KITTITAS COUNTY FIRE MARSHAL'S OFFICE

June 26, 2012

Re: Roberto (BL-12-00012)

After conducting a review of the above named project, I have the following comments:

NOTE: THE PURPOSE OF THIS SURVEY IS A BOUNDARY LINE ADJUSTMENT.

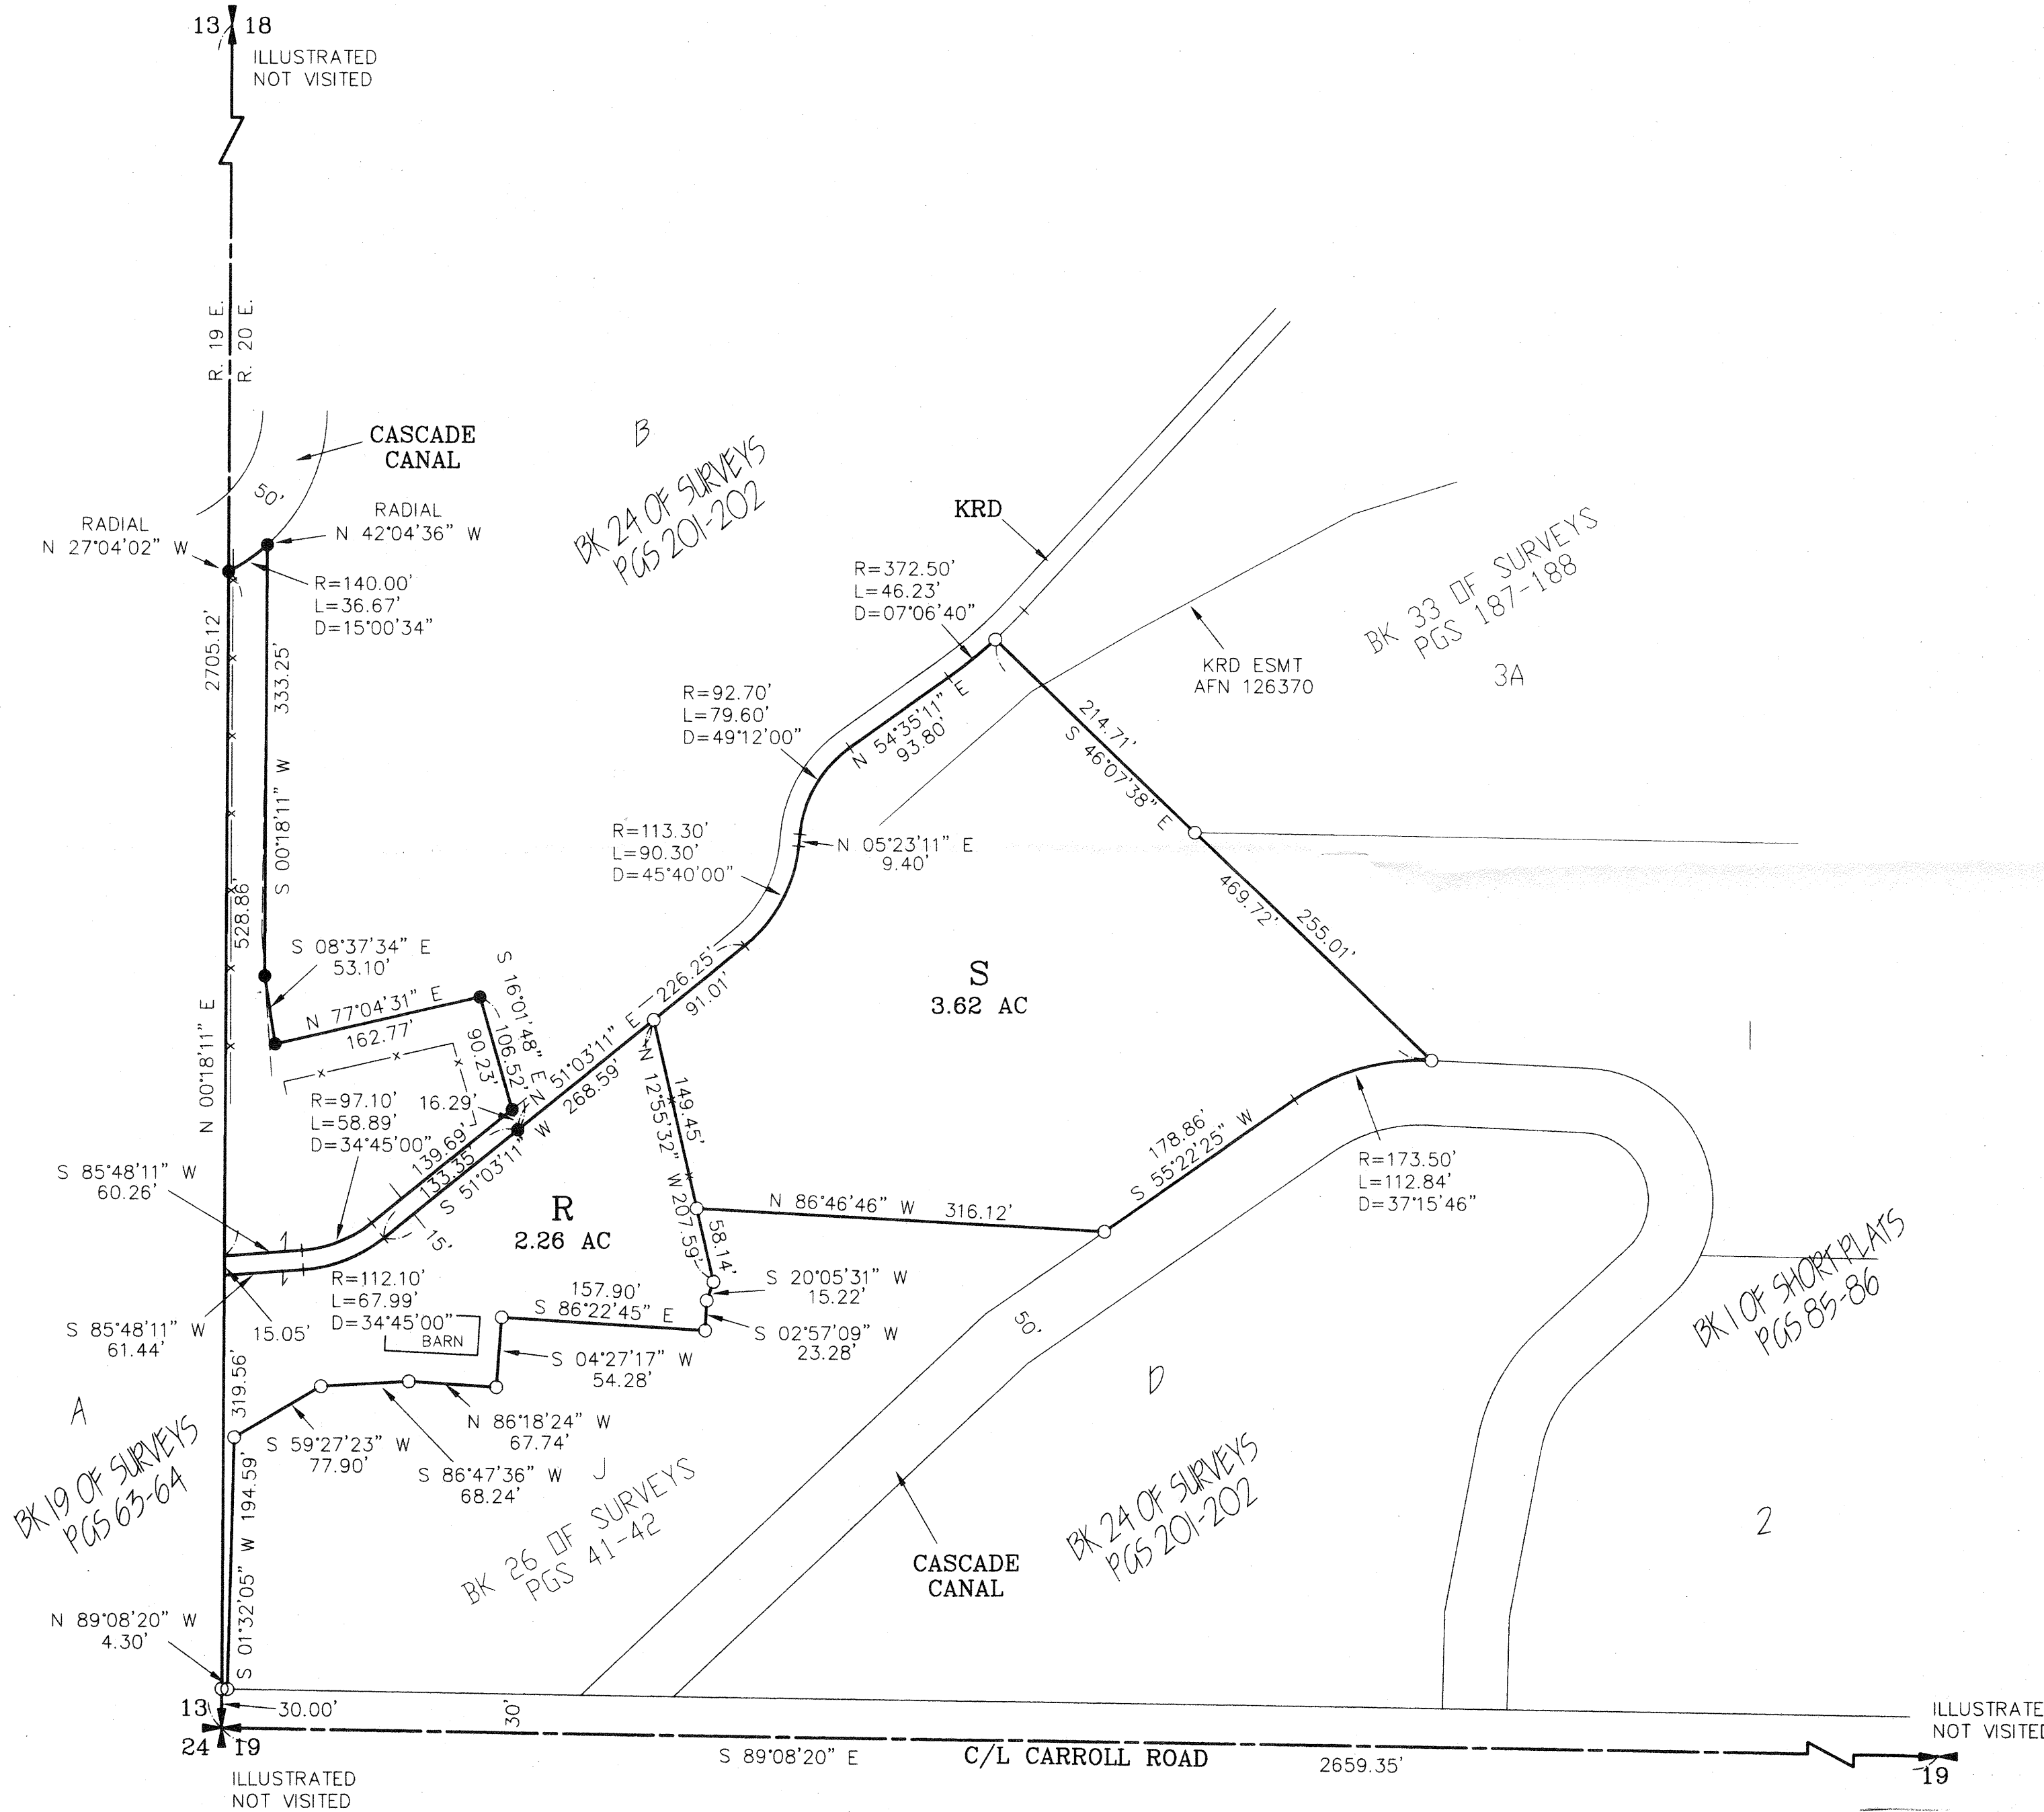
- Ensure that boundary line adjustments do not infringe upon existing structures, to include propane tanks, etc.
- Creation of any additional roads or access must comply with the International Fire Code and KCC Title 12.
- All future development must comply with the International Fire Code.
